Re: Submission to proposed Smithfield Materials Recycling Facility at 132-144 Warren Road, Smithfield (SSD-19425495)

Re: 132-144 Warren Road, Smithfield – Proposed Smithfield Recycle Centre
Application No. SSD-19425495
TRAFFIX Peer Review

PROJECT: 132 WARREN ROAD SMITHFIELD
PROJECT No: 22056
TITLE: SK-02_ FIRE SERVICES SCHEMATIC
REV: 1
DATE: 25.03.2022
DESIGN: AB

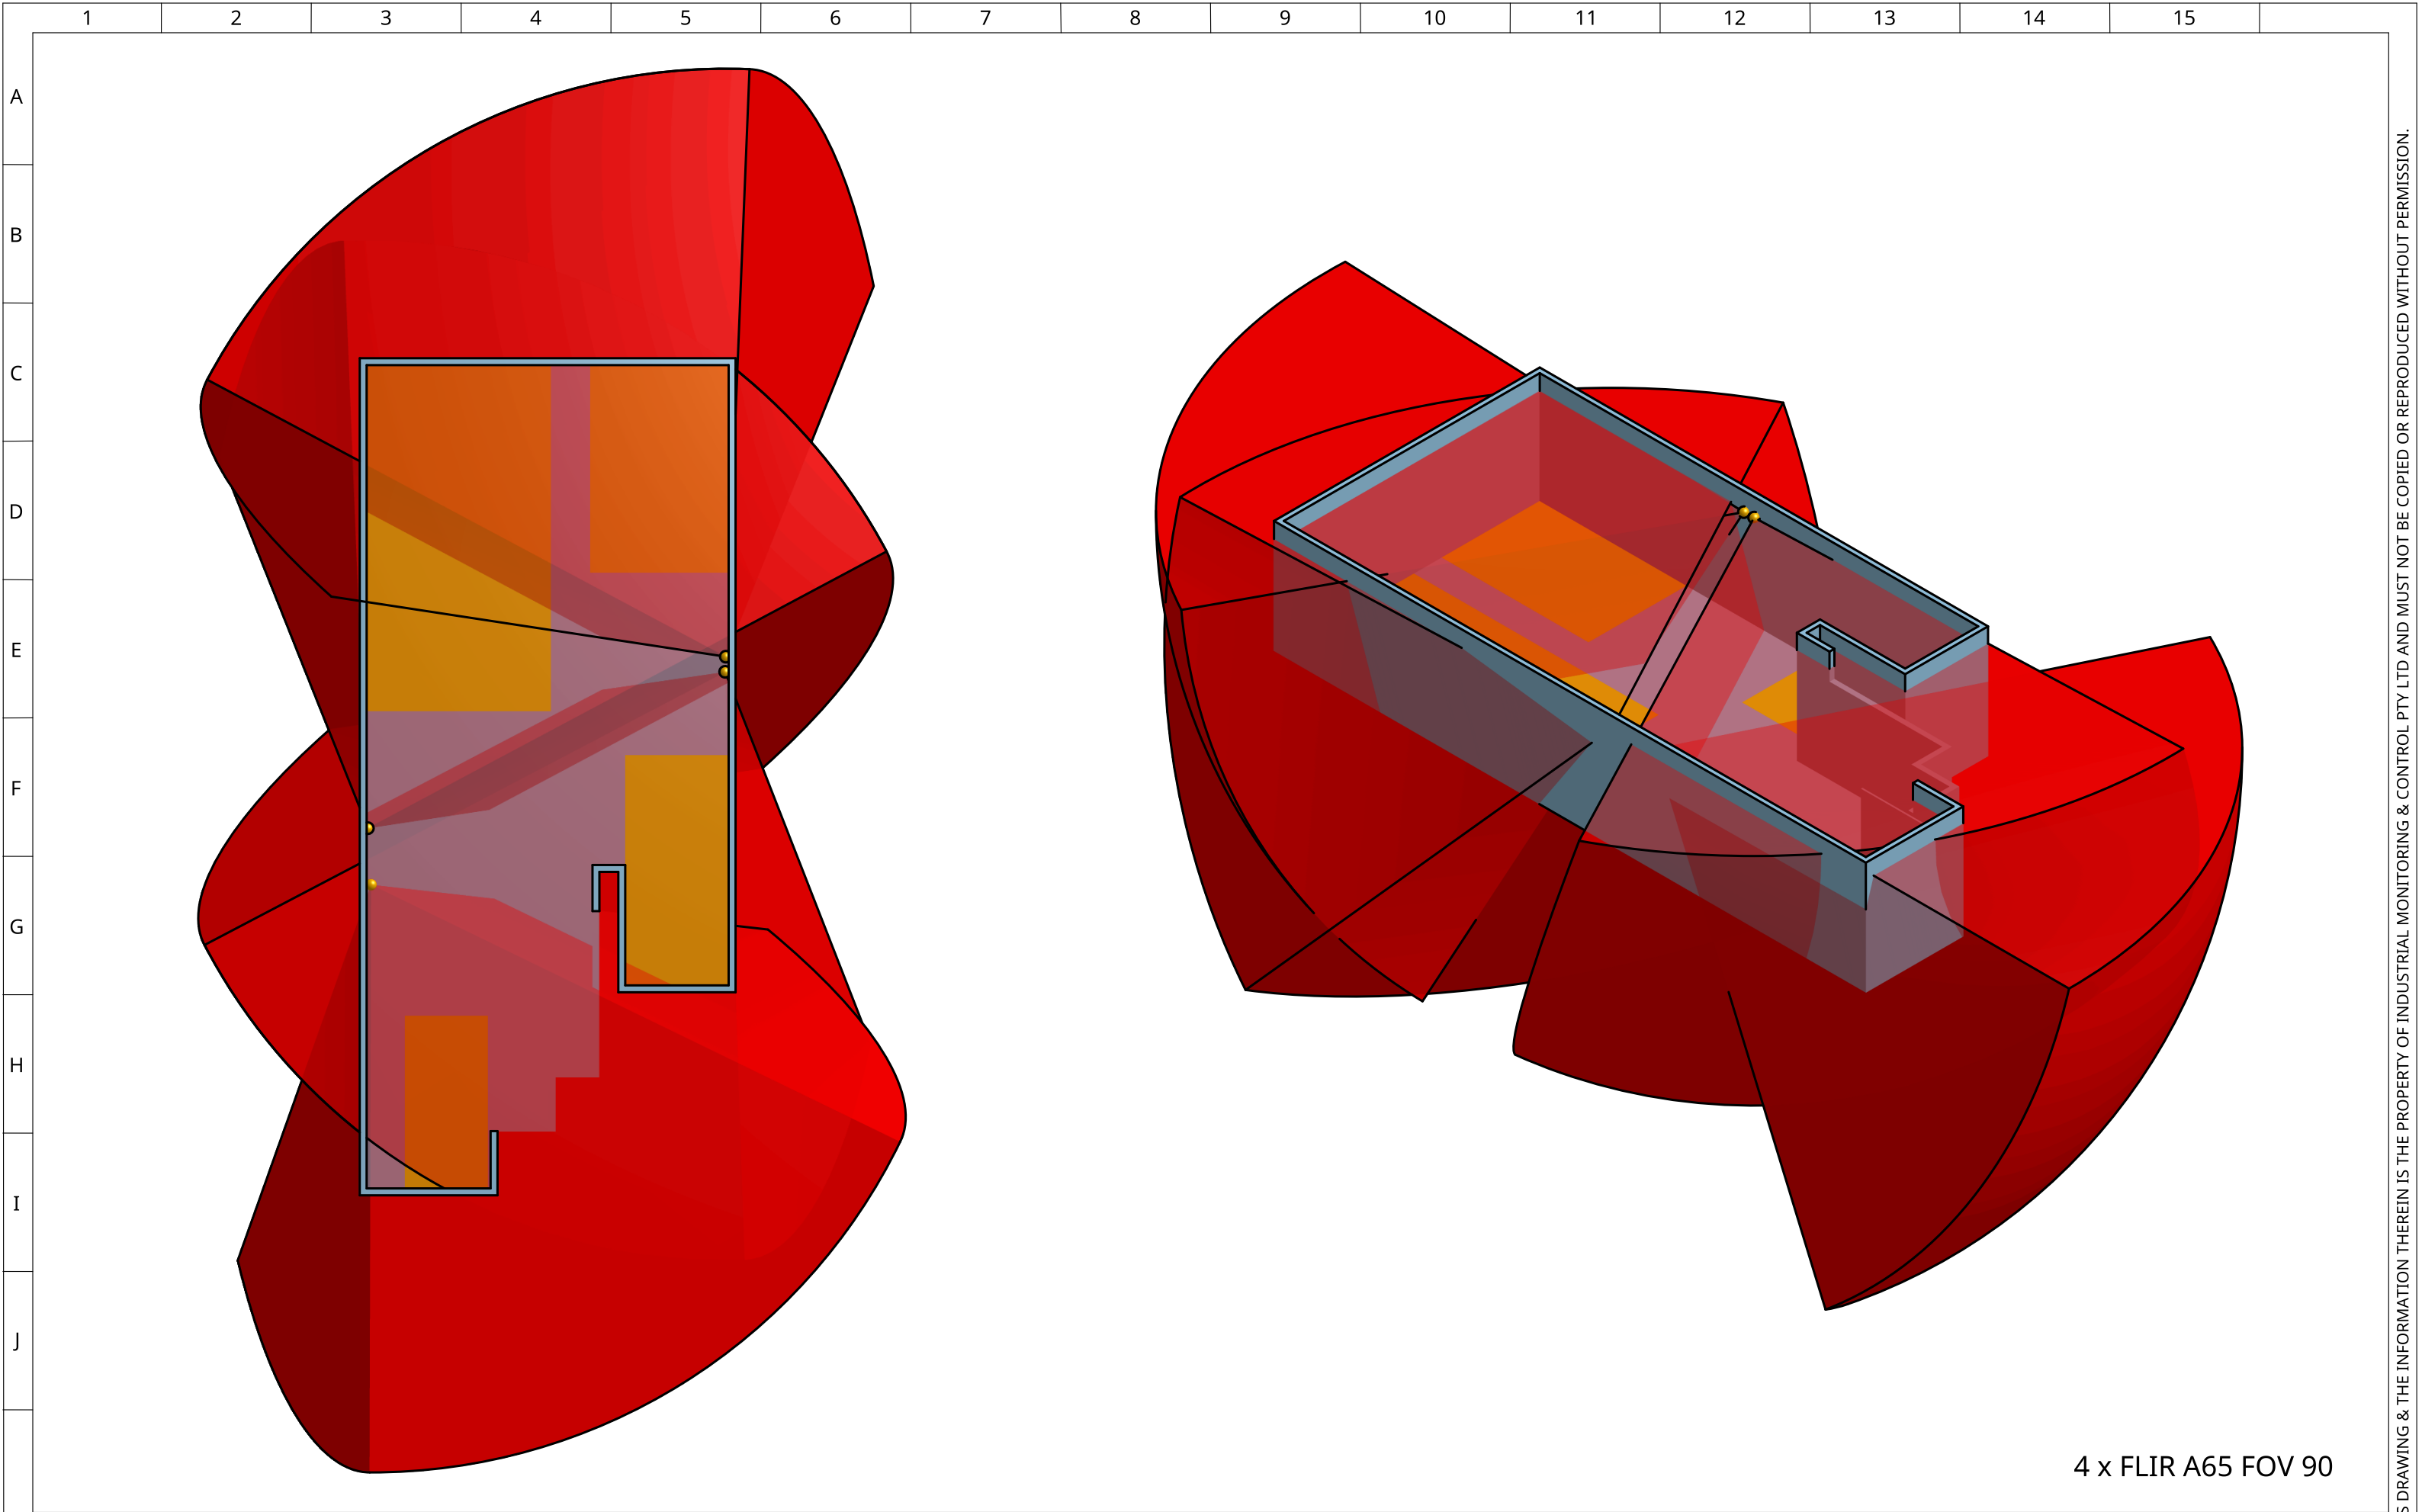
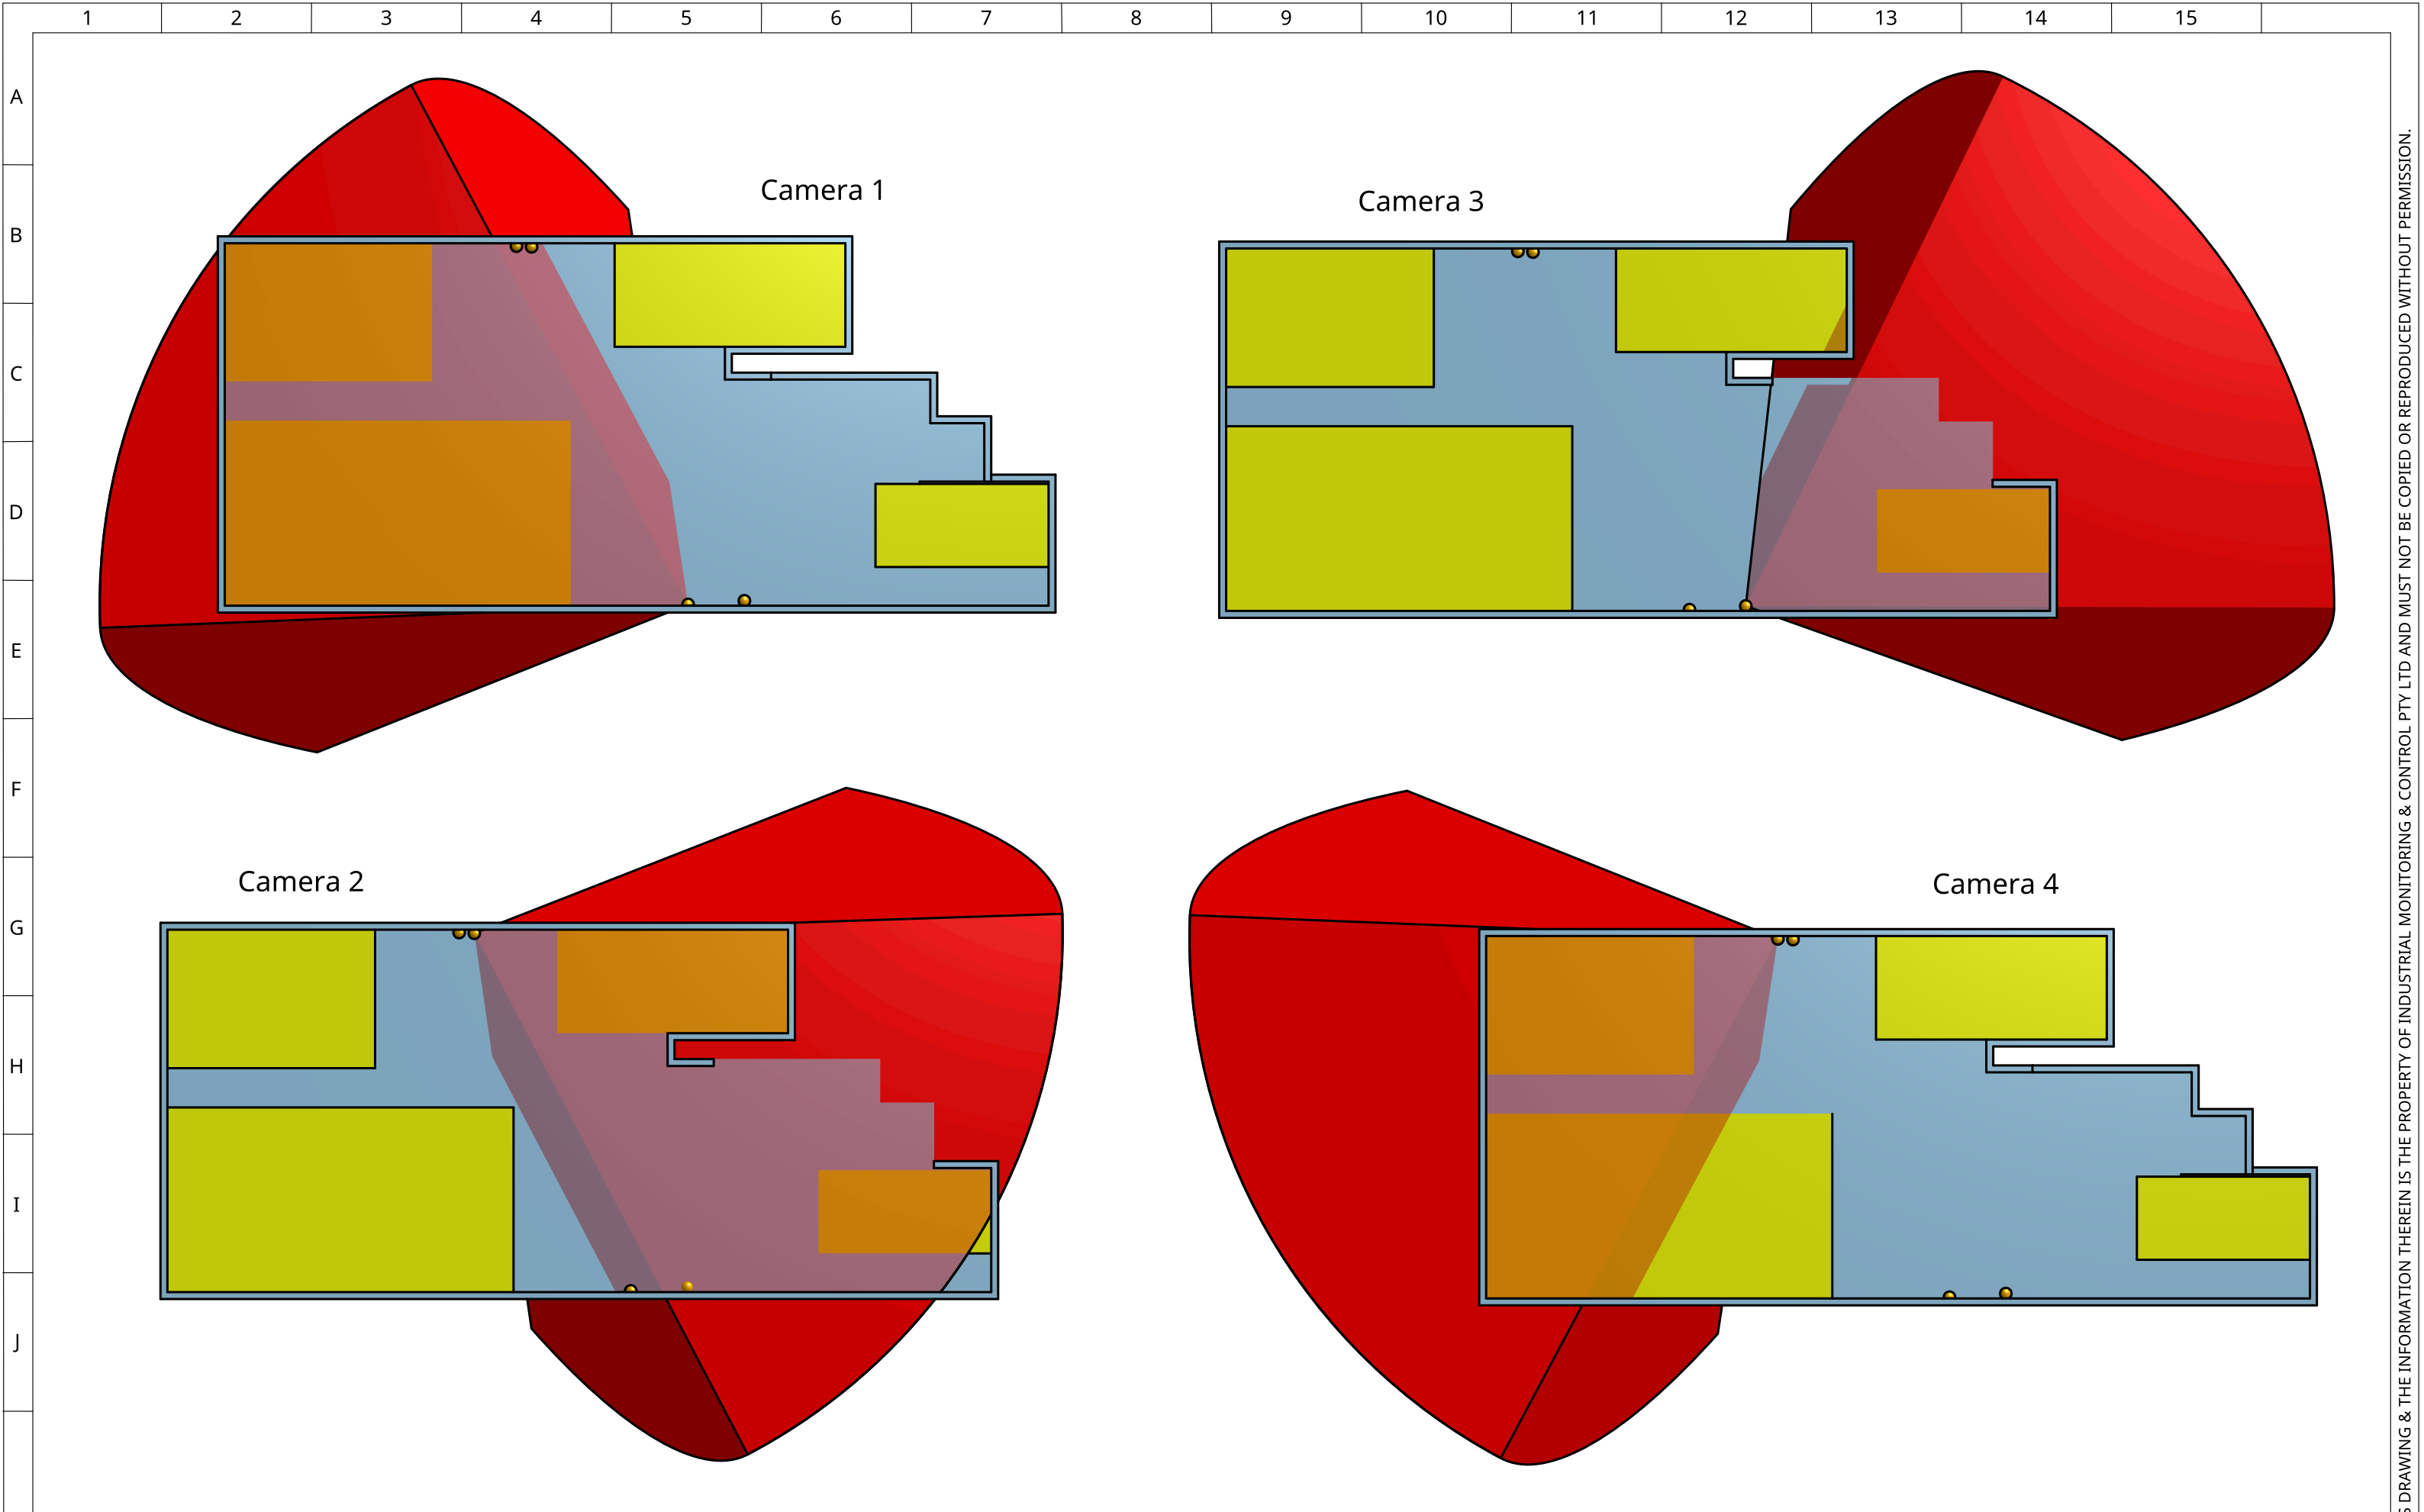
- The proposed design is based on the 2019 edition of the BCA and not the current 2022 version.
- The proposed 'in series' configuration of the fire brigade booster assembly and diesel fire pumpset does not align with the parallel configuration recommended in AS 2419.1:2005.

- The EIS does not address approval and associated requirements for direct suction from a Sydney Water asset by a fire pumpset.
- The single diesel fire pumpset arrangement is not considered to provide sufficient redundancy in the system based on the high-risk nature of the proposed site.
